CITY OF PORTLAND, MAINE

October 28, 2016

Project Name: 23 Ocean Avenue Mixed Use
Address: 23 Ocean Avenue
Applicant: 23 Ocean Avenue Associates, LLC
Planner: Nell Donaldson

Project ID: 2016-150
CBL: 129 G001001

Drawing Title:  
**LANDSCAPE PLAN**

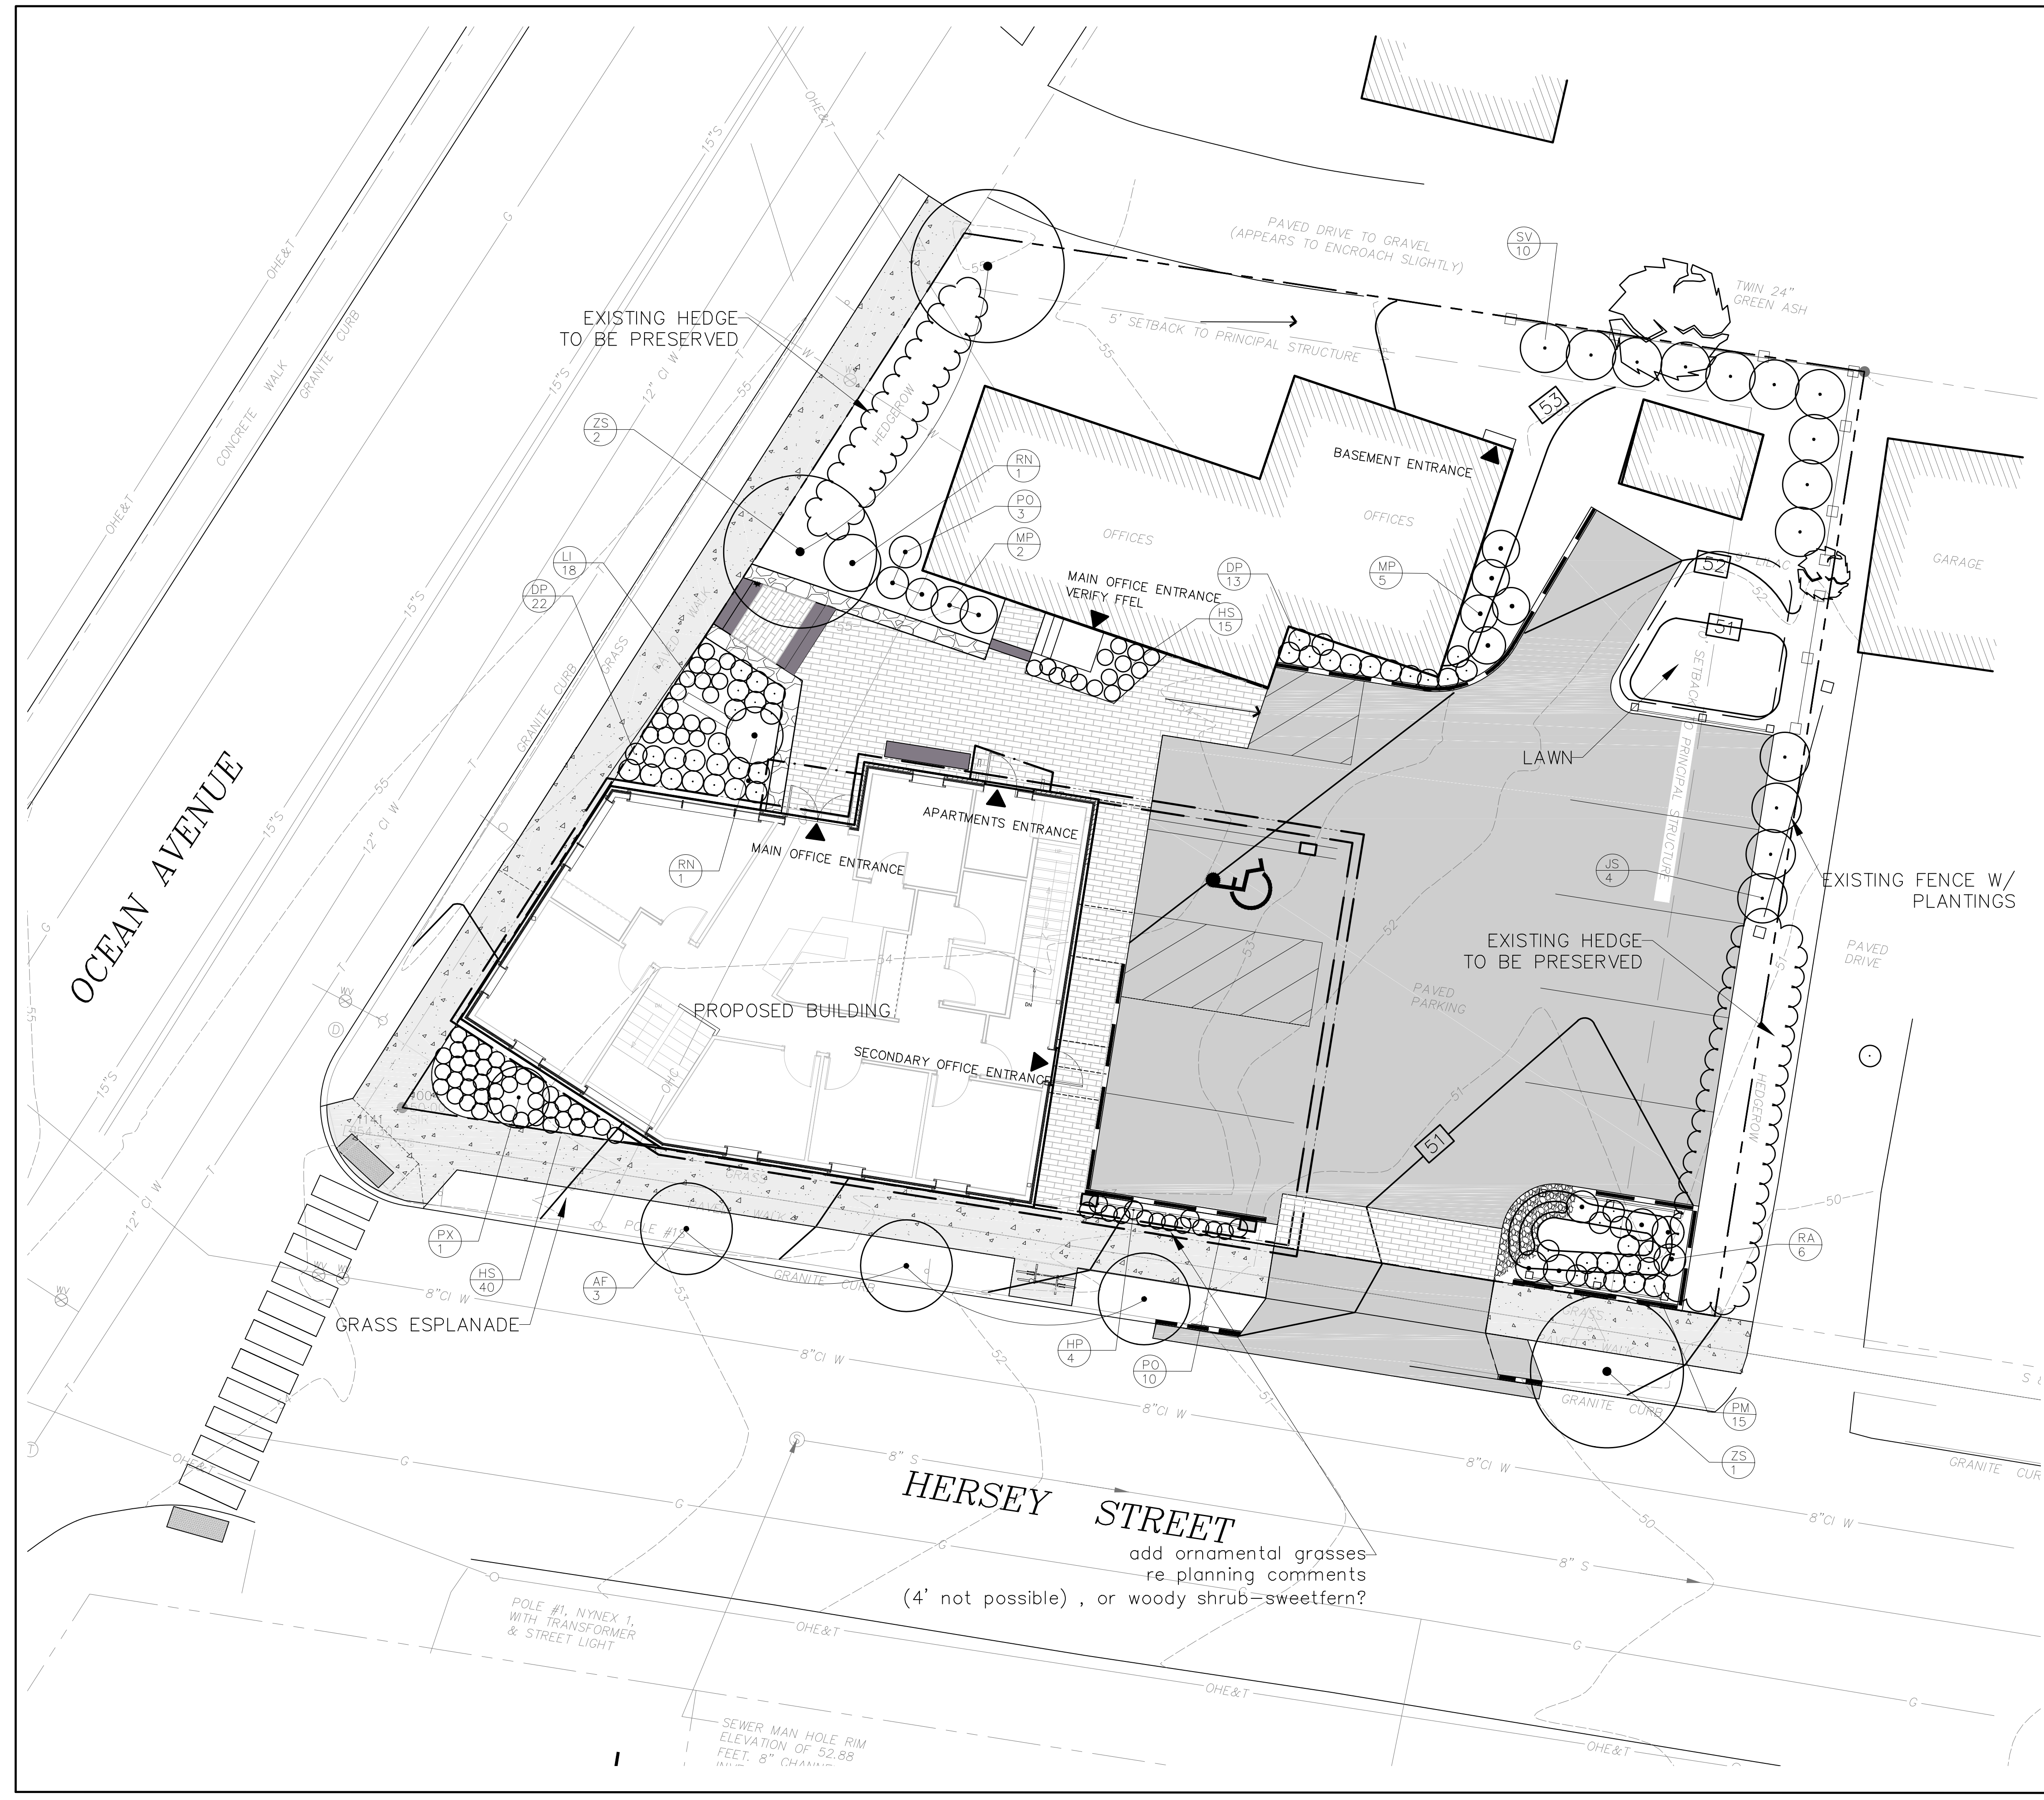
6. Snow storage shall not impinge on the on-site parking. Snow shall be hauled off site as needed; and
7. The applicant shall provide revised plans to address the conflict between the proposed cherry tree and stormwater treatment unit at the corner of Ocean Avenue and Hersey Street for review and approval by the City Arborist and the Planning Authority.

At the request of Jeff Tarling, the city’s arborist, the applicant has revised the landscape plans to show two zelkovas on the Ocean Avenue frontage, three Armstrong maples in the esplanade on Hersey Street, and a cherry tree at the corner of Ocean Avenue and Hersey Street. Collectively, these trees meet the city’s street tree requirement of one per unit. It should be noted that staff has recommended a condition of approval to address a potential conflict between the cherry tree and a stormwater treatment unit proposed for the Ocean Avenue/Hersey Street corner.
